| <b>Application Ref:</b>            | 2025/0339  |  |                     | <br><b>Ribble Valley<br/>Borough Council</b><br><a href="http://www.ribblevalley.gov.uk">www.ribblevalley.gov.uk</a> |
| <b>DELEGATED ITEM FILE REPORT:</b> |            |  |                     | <b>REFUSAL</b>  |

| <b>Development Description:</b> | Proposed two-storey extension to side with integral balcony. |
| <b>Site Address/Location:</b>   | Holly House, 8 Station Road, Rimington BB7 4DR.              |

SHEET: Proposed plan and elevations

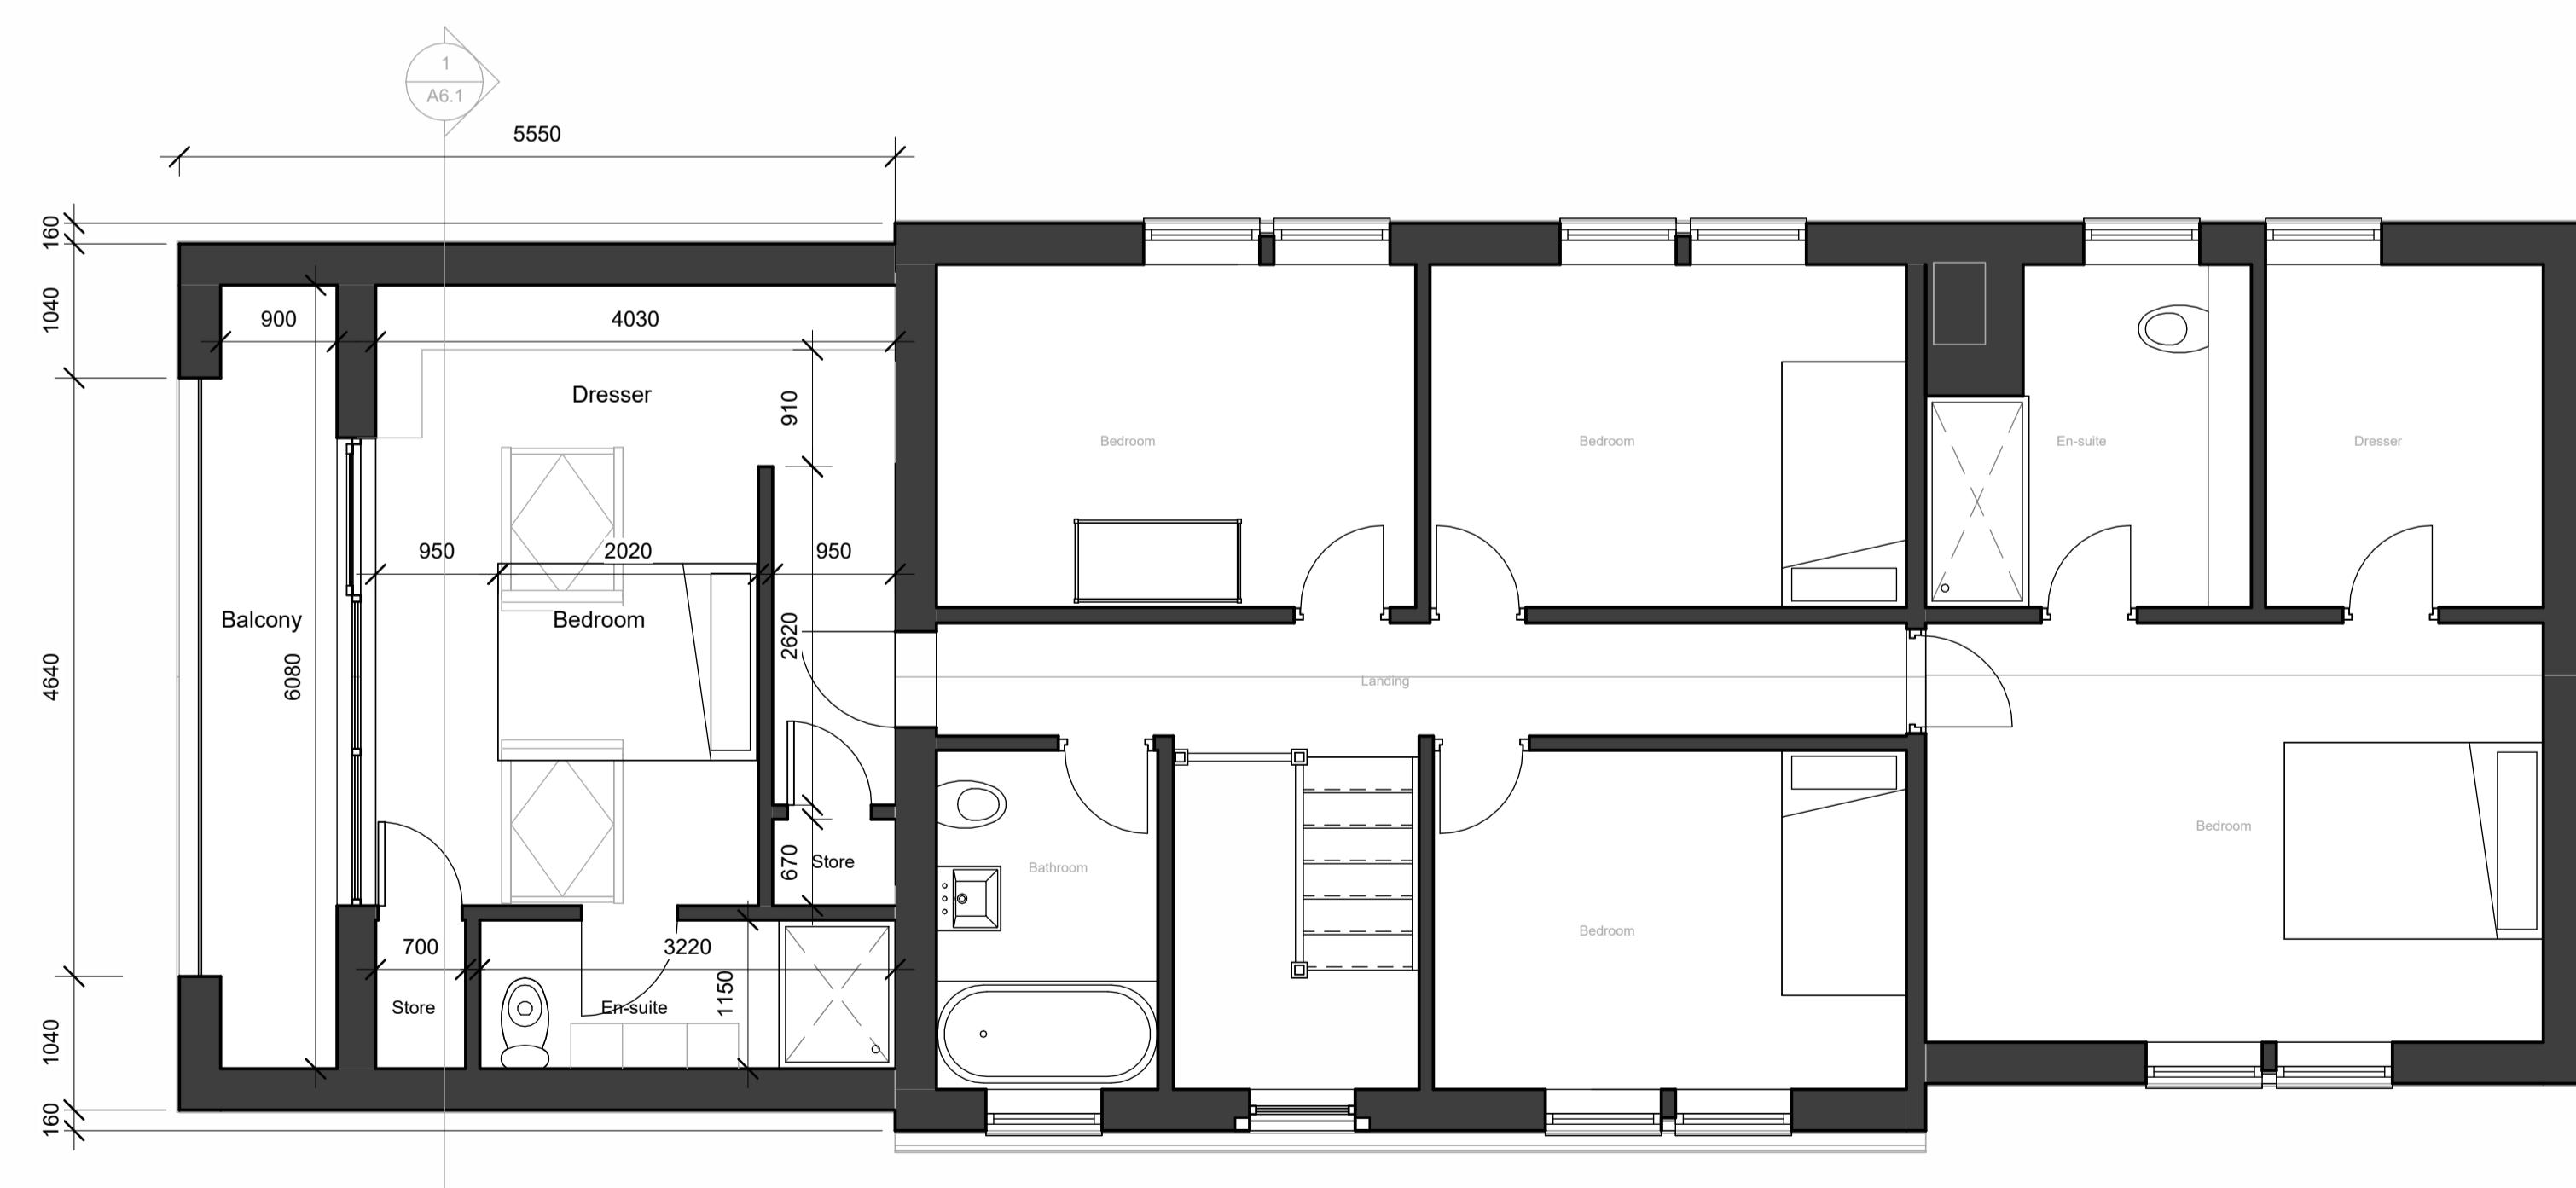
The proposed first floor balcony extension would be constructed in stone to match the existing dwelling with a slate roof profile. Given the materials are consistent with the existing dwelling the proposal would integrate sufficiently in this respect. However, the proposed window/glazing arrangement is anomalous and unbalanced. The proposed principal elevation at first-floor level is blank and lacks any architectural interest. Given the prominence of this elevation and when viewed in relation to remainder of the fenestration, it reads as incongruous. In contrast to this, the proposed side elevation features several large sections of

glazing and a glazed balcony (in addition to rooflights) is somewhat overdeveloped, in contrast with the remainder of the dwelling but particularly to the proposed rear and principal extension elevations. It is therefore considered that the glazing arrangement is unbalanced of harm to the character of the dwelling. The visual harm would be further exacerbated by virtue of the first-floor extensions position on the northern elevation of the dwelling, immediately adjacent to the highway.

The proposed first-floor extension will extend the entire width of the existing ground-floor outrigger and will feature a minor set-back from the rear and principal elevations of 0.16m. Whilst a set-back does generally help in reducing the overall bulk and massing of an extension, as well as helping to maintain subservience to the host dwelling, in this instance the set back is not substantial enough to achieve this. The proposed extension therefore results in the creation of a dominant and disproportionate addition to the property. Furthermore, given the proposal is only set back at first floor, with the ground floor elevations remaining flush with the existing building line, it results in the first-floor extension failing to appear cohesive with the existing dwelling. This results in a disproportionate form of development that will create imbalance. Upon the approach from the north of Station Road, the extension would host a dominant position and given the higher ground level in which the dwelling sits, would be the most visible feature upon said approach. The development would fail to take a subservient position to the application dwelling resultant.

As such, based on the above observations, the proposed development will have an unacceptable impact on the visual amenities of the area and the character of the application dwelling, by virtue of an anomalous and prominent feature to the northern elevation. This is contrary to Policies DMG1 and DMH5 of the RVCS.
